Land North of Sefter Road, Pagham - P/49/21/RES RM Application

Response to ADC Drainage Consultation Comments dated 28 May 2021

Drawing Title: Surface Water Drainage Strategy Layout

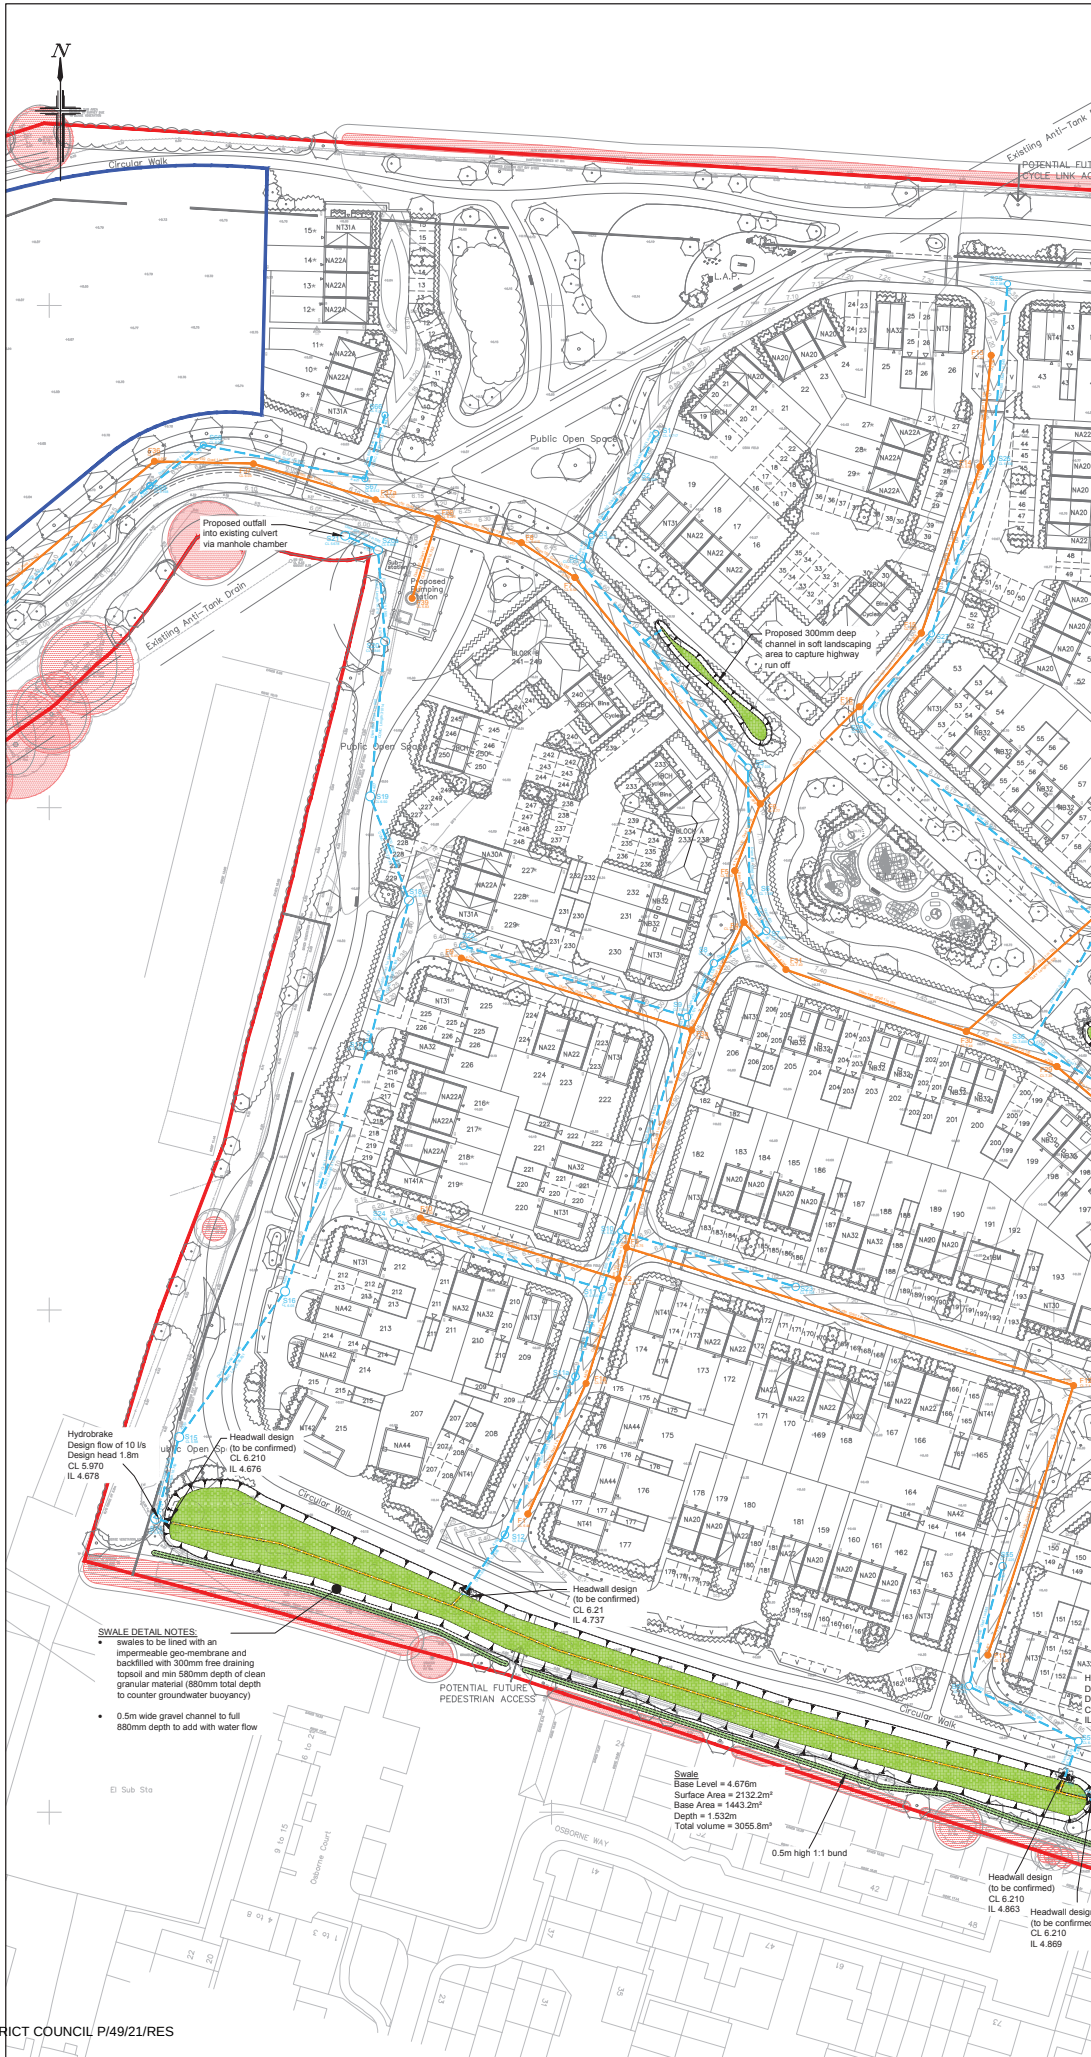
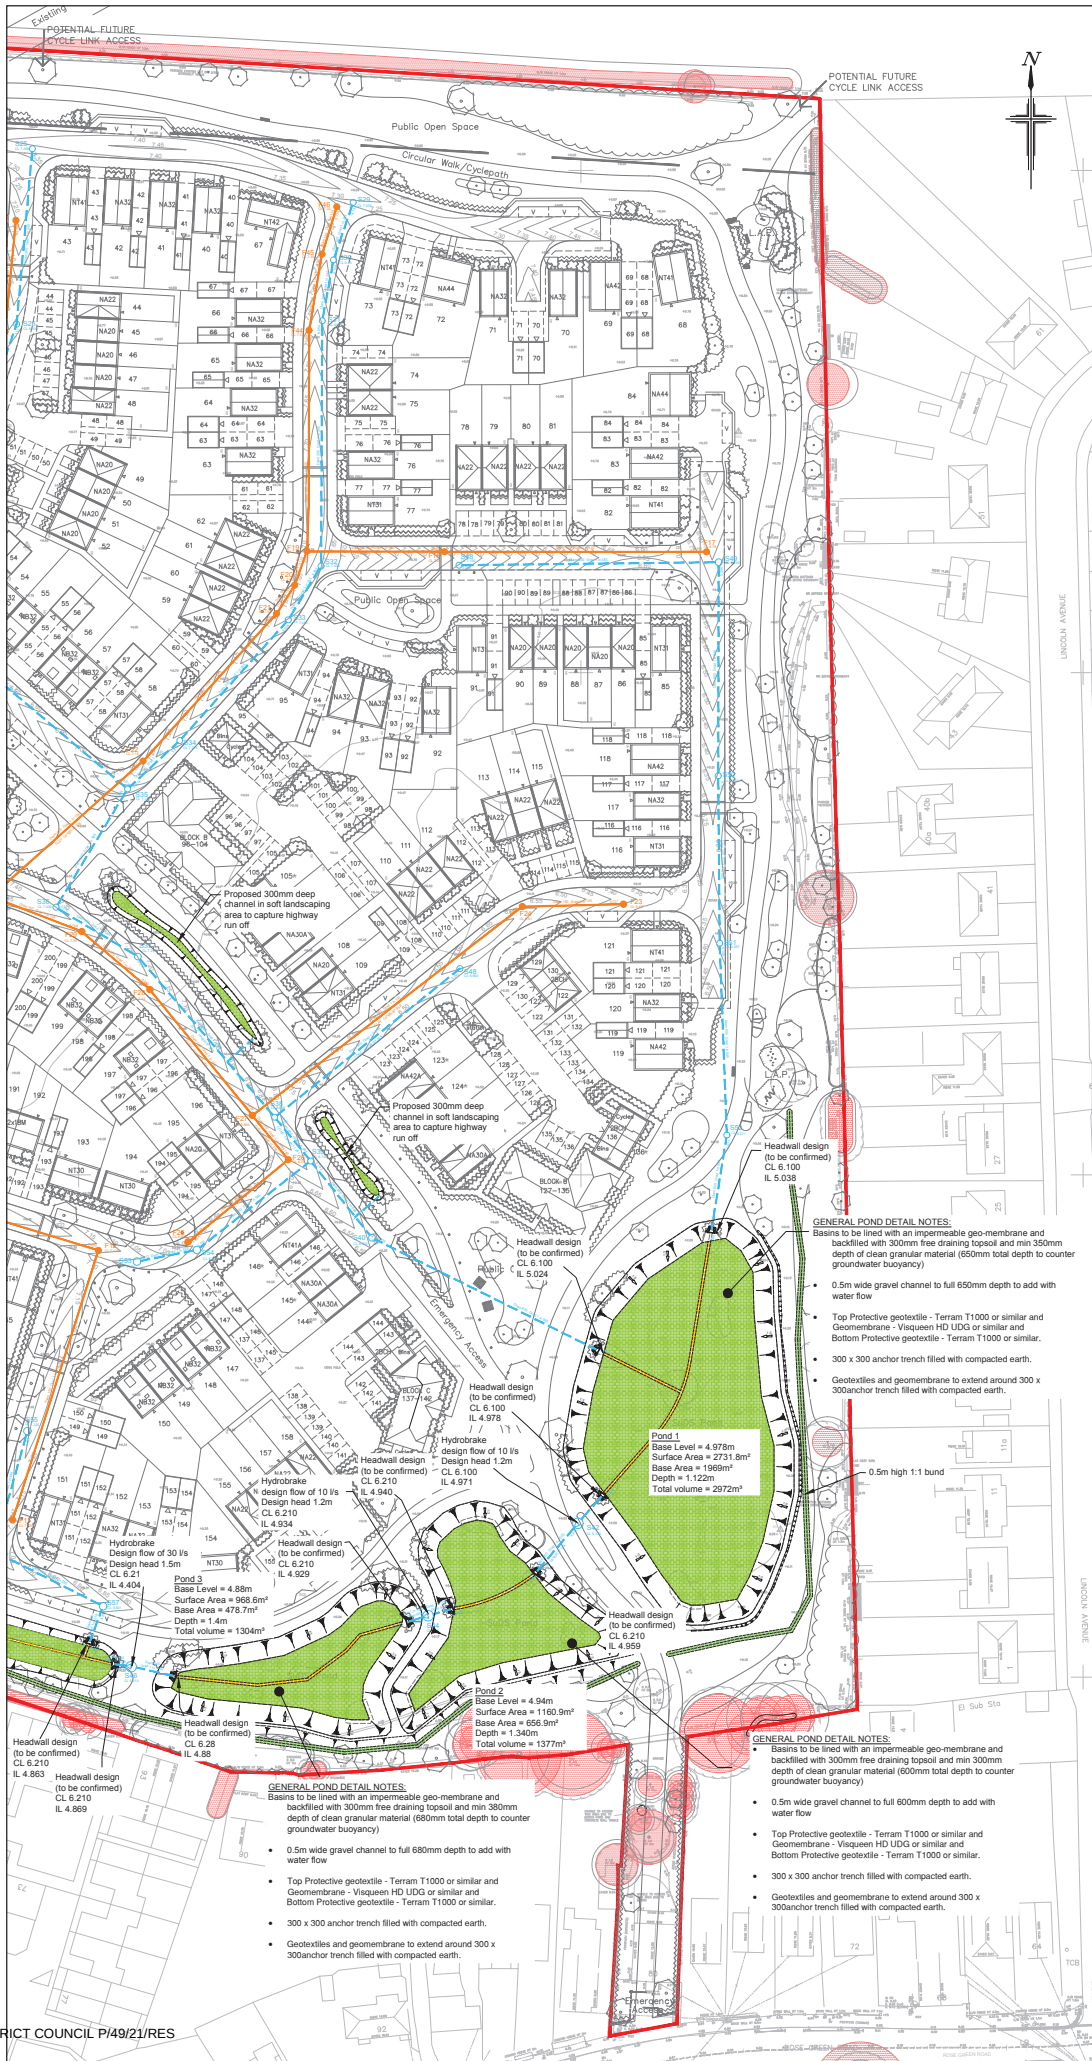
2.	Please make it clear on plans where points of discharge are. The eastern network appears to have a discrepancy on the label for S46. The leader indicates an I.L of 4.4.04 but the actual network label indicates 4.872 which tallies with calcs. Without zooming in this does cause some confusion as it appears the network breaks its back based upon the leaders.	Noted this will be made clearer on the discharge of conditions submission (condition 10 – details of surface water drainage scheme pursuant to Outline planning permission ref. P/134/16/OUT).

6.	Please provide a manhole schedule printout for network 2 in microdrainage.	Provided as attached with FEH calcs.
7.	The leader for S79 indicates a discharge rate of 3.5l/s but in calculations this is 3l/s please ensure consistency.	Noted, whilst the peak flow is 2.9l/s for this network, the design criteria for the hydrobrake is 3.5l/s with associated design head to provide an efficient hydraulic discharge curve. The note on the drawing is relating to the hydrobrake peak flow criteria. This will be made clear on the discharge of conditions submission.

ADC Drainage comments	Applicants Response
8.	There are inconsistencies between calculations and the layout for; the attenuation tank at S80, pond at S75, pond at S79, please update.	Noted this will be made clearer on the discharge of conditions submission.

12.	We note that the watercourse around pond 4 is proposed to be diverted, we are concerned by how little distance there is between the pond and watercourse.	This has been addressed in the updated layout, with the diverted watercourse offset further from the edge of the new SuDS basin to suit.
